**From:** [REDACTED]  
**To:** [A38 Derby Junctions](#)  
**Subject:** For the attention of the A38 Derby junctions Case Team  
**Date:** 26 October 2021 22:39:59  
**Attachments:** [AirP A52 wait.docx](#)

Response to National Highways response to the Secretary of States Statement of Matters

Drawing Title  
FIGURE 2.6  
MARKEATON JUNCTION  
GENERAL ARRANGEMENT

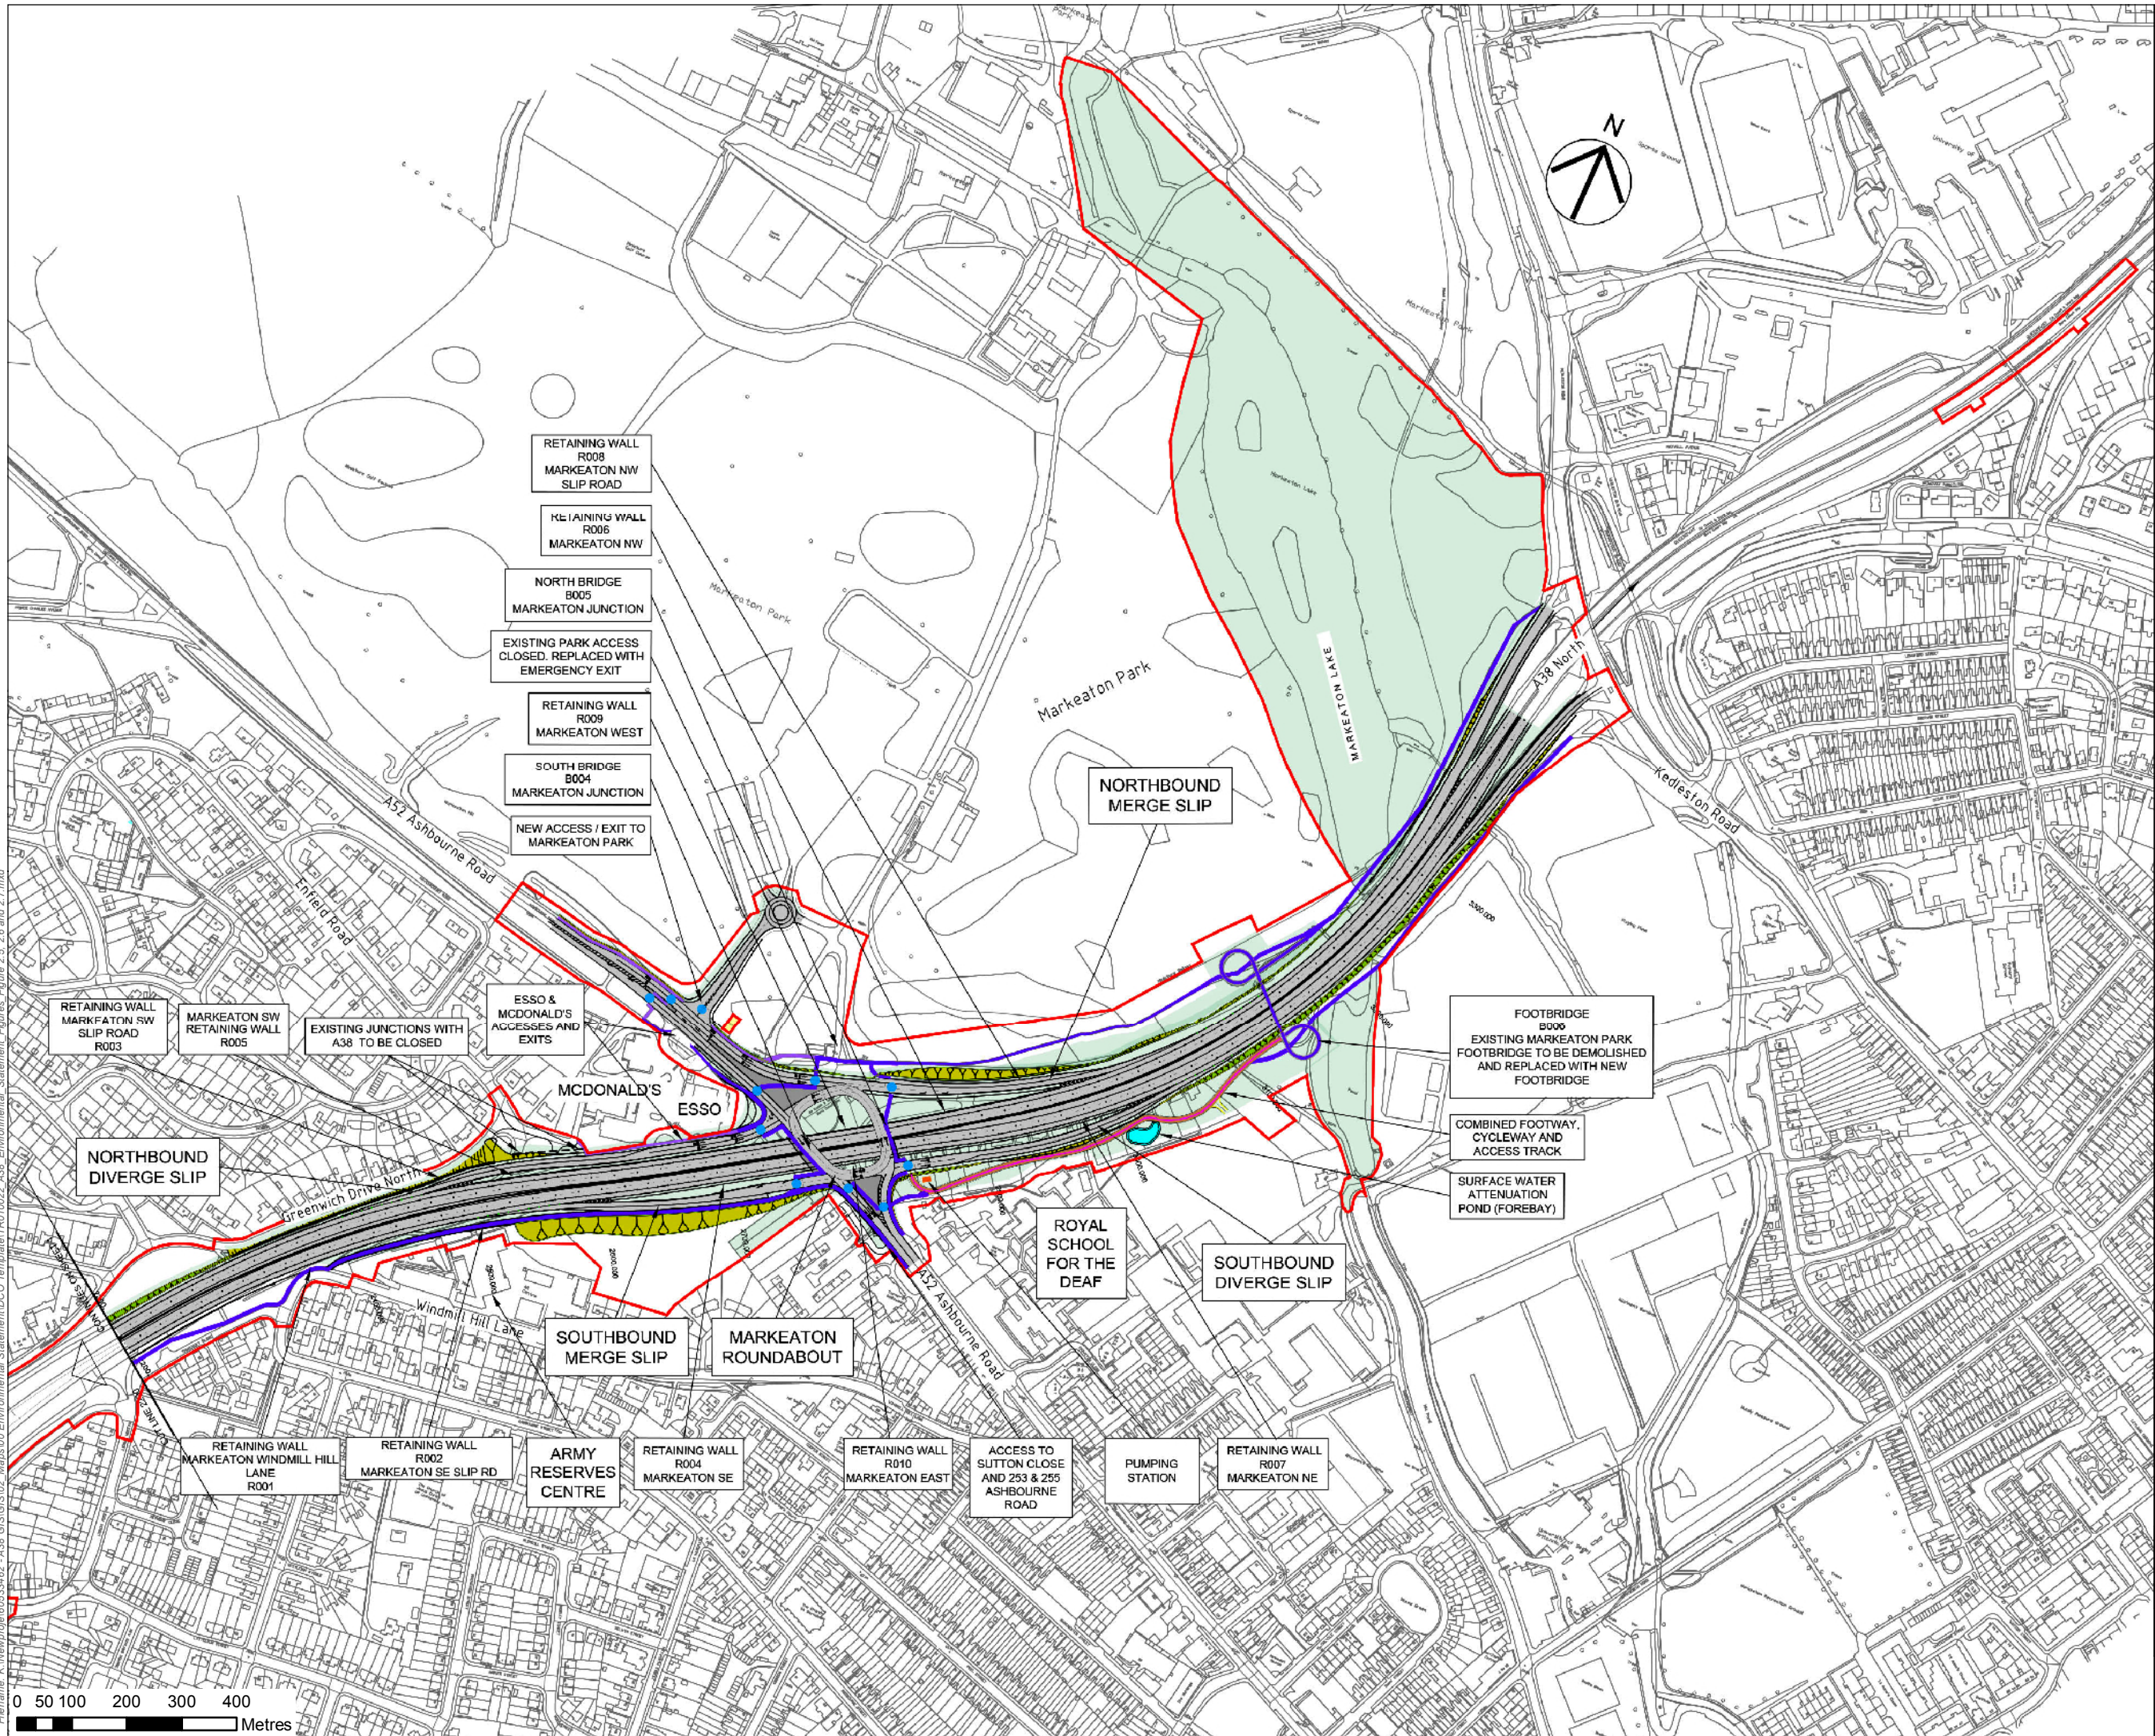
The proposals to move the entrance of McDonalds, Eurogarages and the entrance to Markeaton Park to the A52 Asbourne Road will lead to an increase in queueing there. That will lead to an increase in Carbon emissions and in NO2 and in particulate pollution.

At present traffic can enter the park from the North and South and East without waiting and blocking the progress from the East of Derby along Ashbourne Road.

National Highways never answered my question "What are vehicles that need to enter Markeaton Park supposed to do when they find that the Right turn Lane is already full?"

I suspect that if the scheme is allowed to proceed there will be a lot of accidents there.
